SUBJECT: Engineering Review Comment
Mountain View Electric Association Inc. (MVEA)

Project Name: Murr Subdivision – 14090 Davis Road

Project Number: MS231

Description: Proposed development of a total of 4 single family lots located east of Blaney Rd. and west of Curtis Rd. in Township 13S, Range 64W, Section 33.

MURR SUBDIVISION

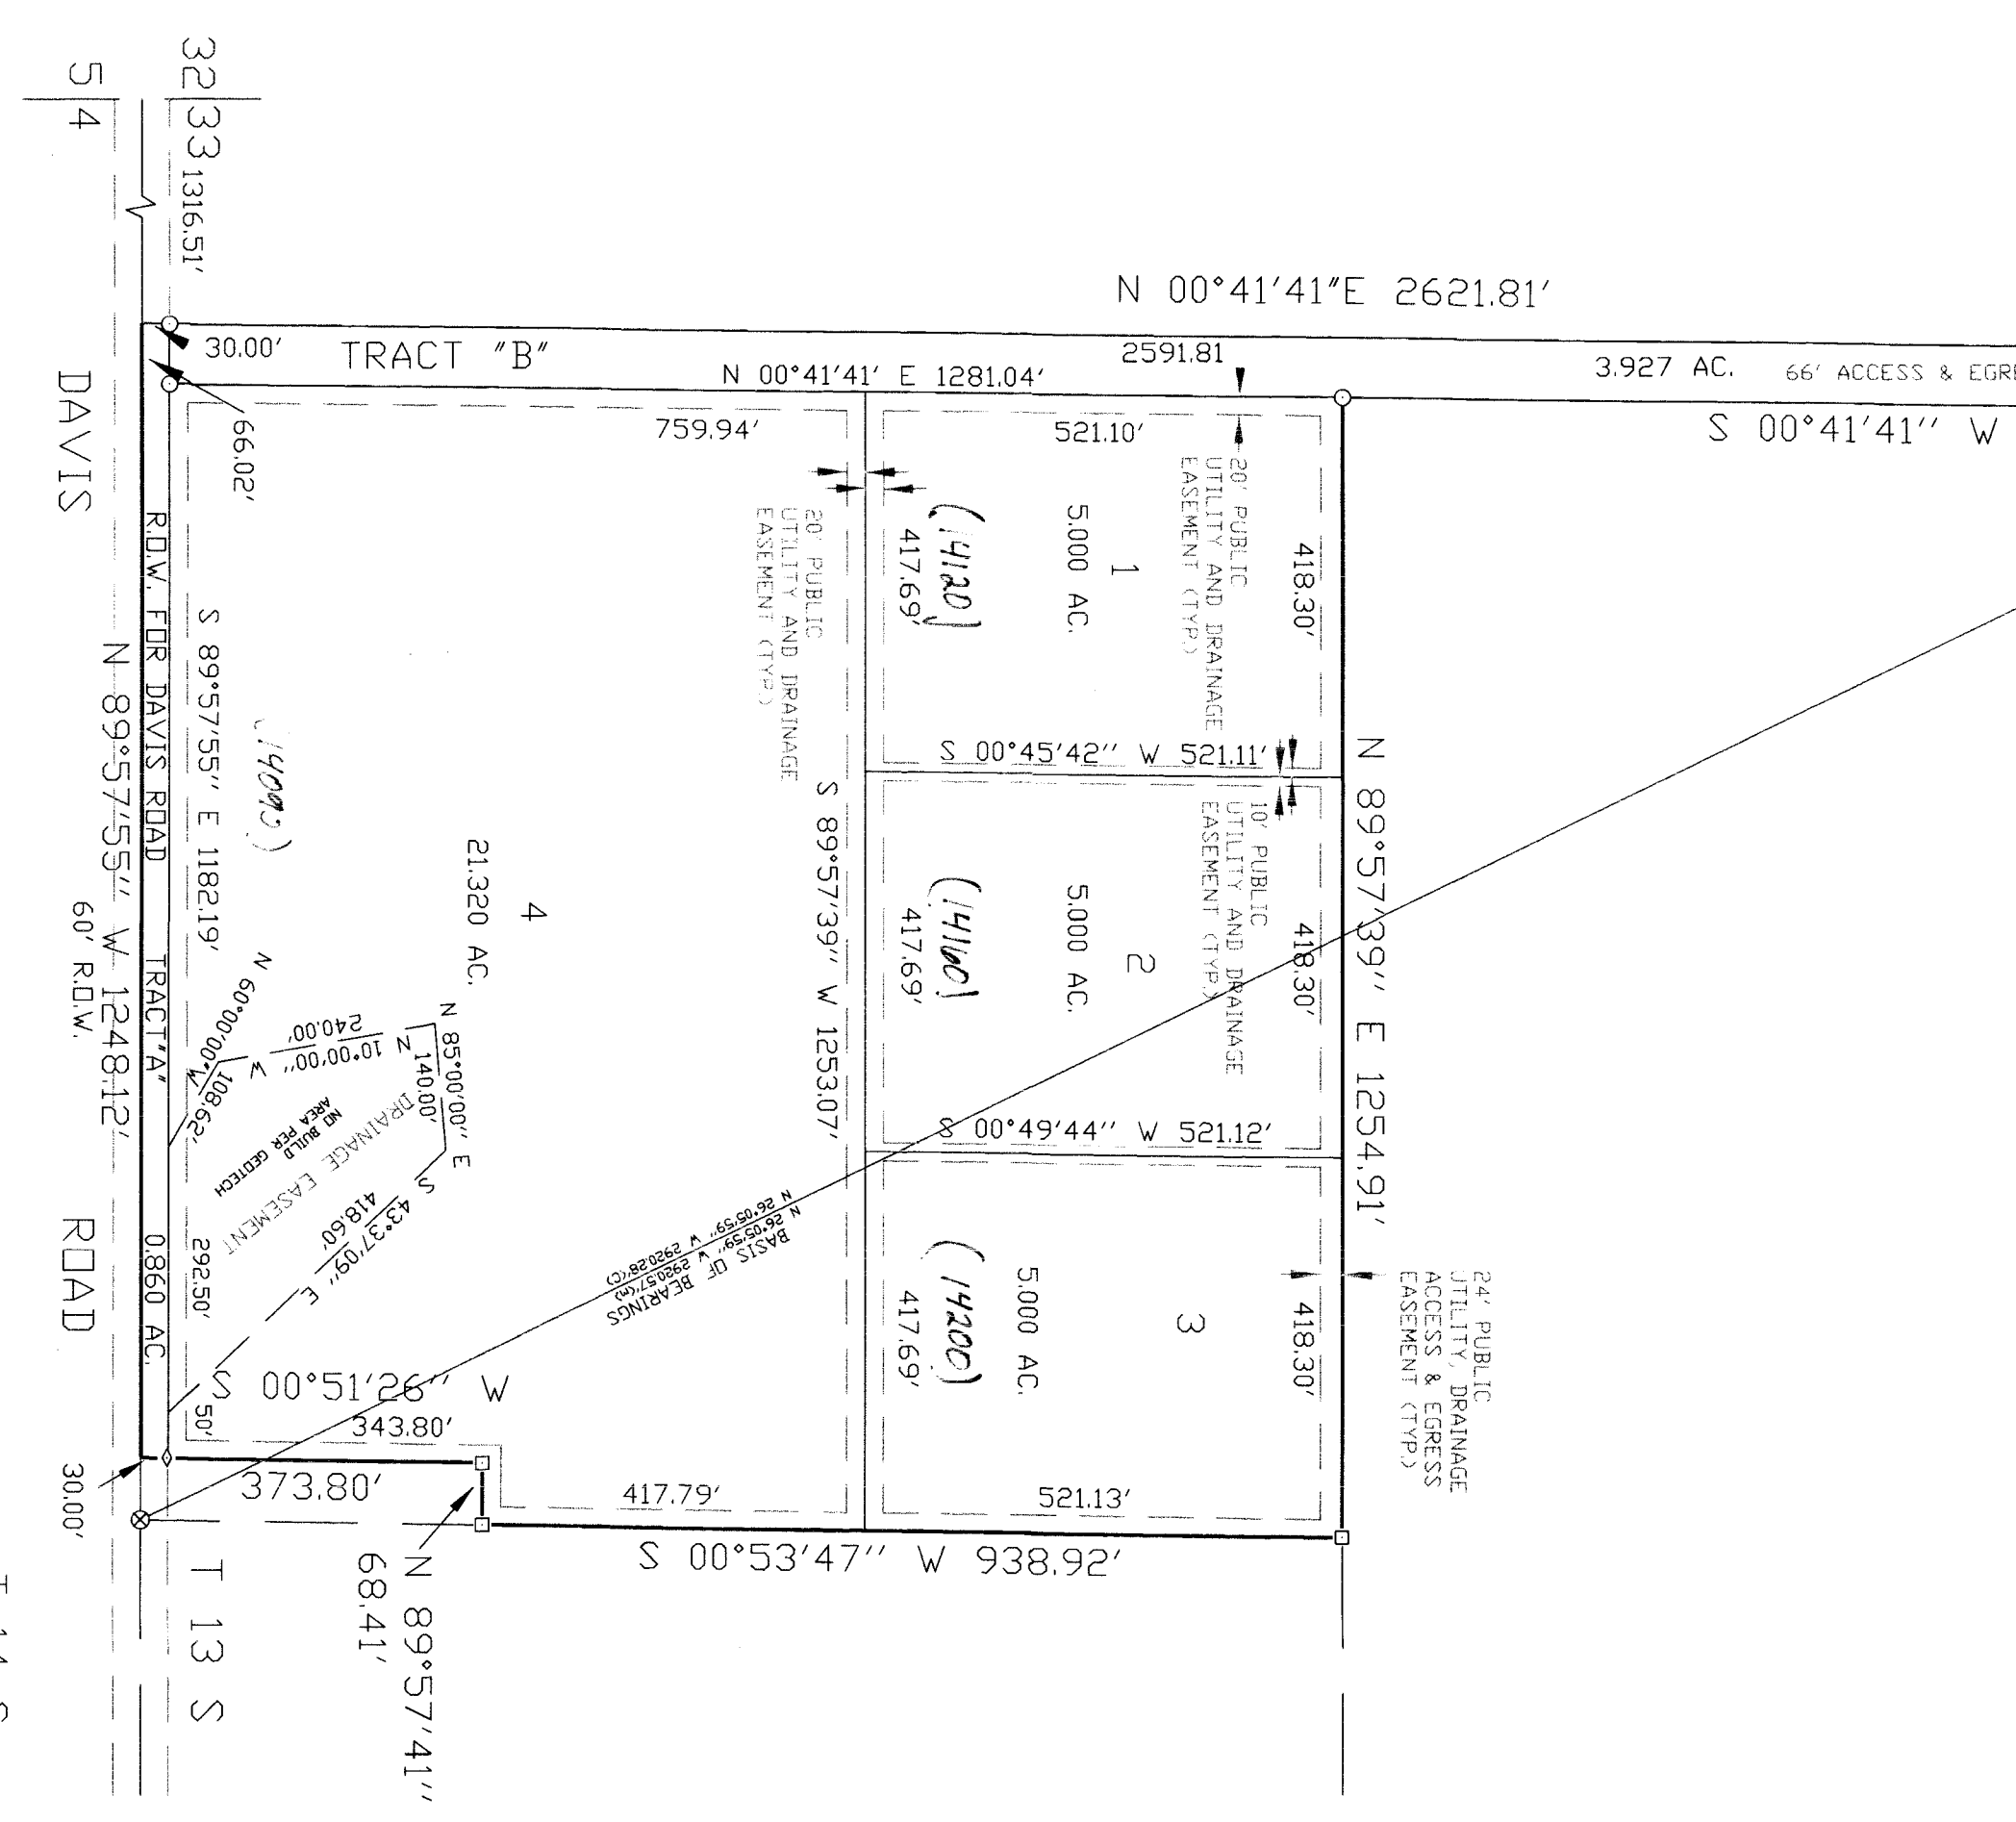
MVEA requests a ten (10) foot front, side, and rear lot utility easement and all tracts, along with a twenty (20) foot exterior utility easement on the plat. MVEA also requests the platting of MVEA's existing facilities with easements on the plat. Additional easements may be required.

MVEA has existing facilities near and within this parcel of land. If there is any damage, removal or relocation of facilities it will be at the expense of the applicant.
